Recommendation Report for Planning Permission for Works or Extension to a Dwelling

REF NO: BN/113/21/HH

LOCATION: 26 Gospond Road
Barnham
PO22 0EU

PROPOSAL: Erection of two storey side extension and loft conversion with 1 x rear dormer following the demolition of existing single storey front and side extensions

PROPOSED FRONT ELEVATION 1:100

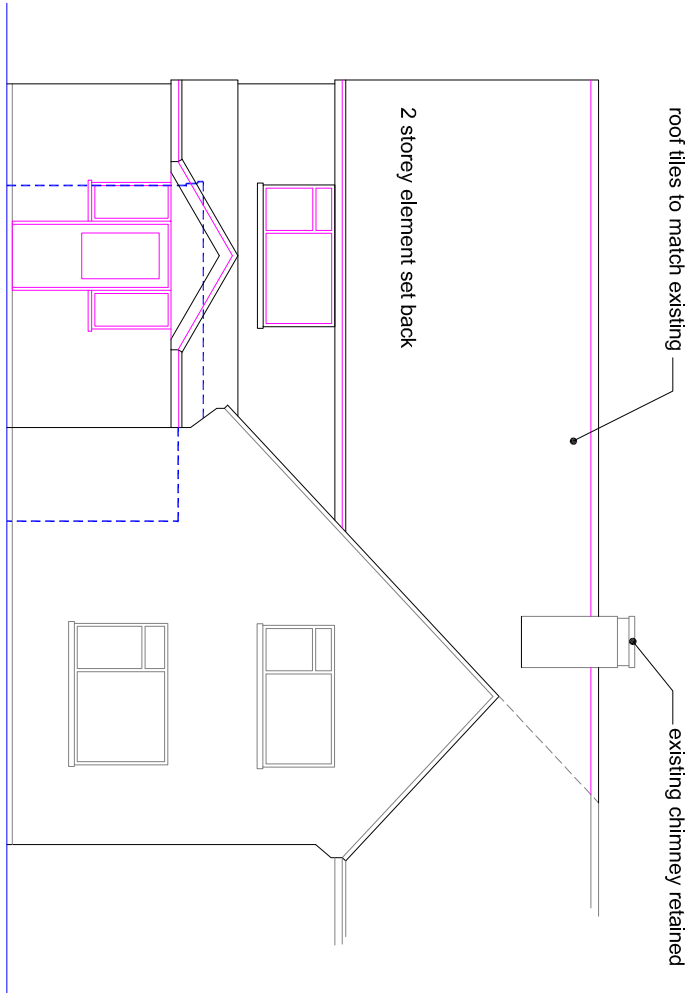
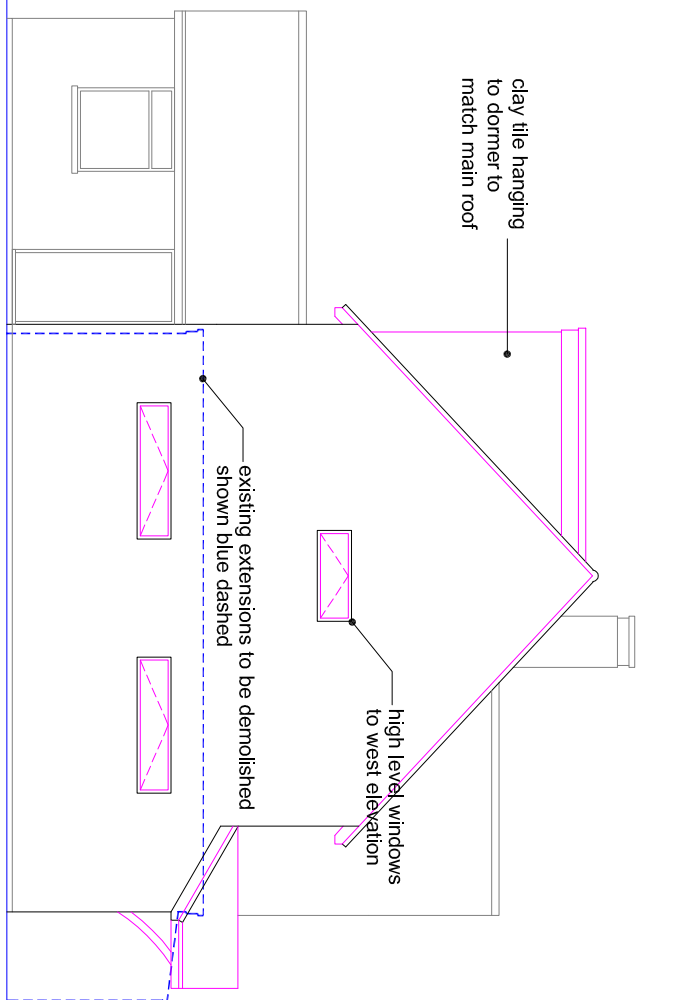
The proposal is visible from the street scene however the property is located to the end of the road which is a dead end and therefore passing traffic is minimal.

The dwelling features a cat slide roof to the western side and has an existing single storey side extension. The extension will be replaced with a two storey extension and the width will increase by 1.4m. It will have a gable end roof and therefore adds bulk to the side elevation of the property.

The development is set back from the principle elevation by 1.15m and therefore is not considered unduly dominant.

The side addition although does not appear a subservient addition in conflict with DDM4 (b) although is well integrated. The surrounding area consist of properties of a similar design and style, however there is a property at No.31 which has had an extension of similar design to that proposed and it is therefore not considered out of character with the area. The rear dormer is large although with no viewpoints from the street scene is acceptable.

PROPOSED REAR ELEVATION 1:100

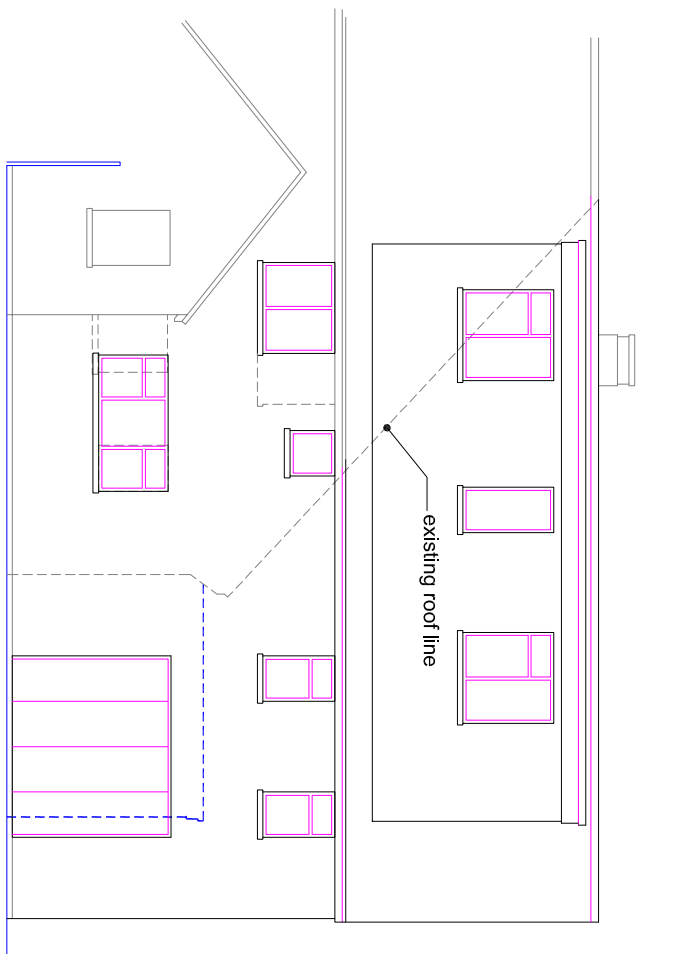
There will be a dormer to the rear which extends predominately across the new roofline. This has a length of 7.6m, depth of 3.1m and a height of 2.8m. This is not considered overbearing or overshadowing due to it siting on the roof slope.

The dormer has 3 windows serving a landing, office and bedroom. This may offer some views over the garden of the neighbouring dwelling although due to the siting, views are limited and acceptable. There

are also no properties to the rear and the dormer is not considered to result in adverse overlooking.
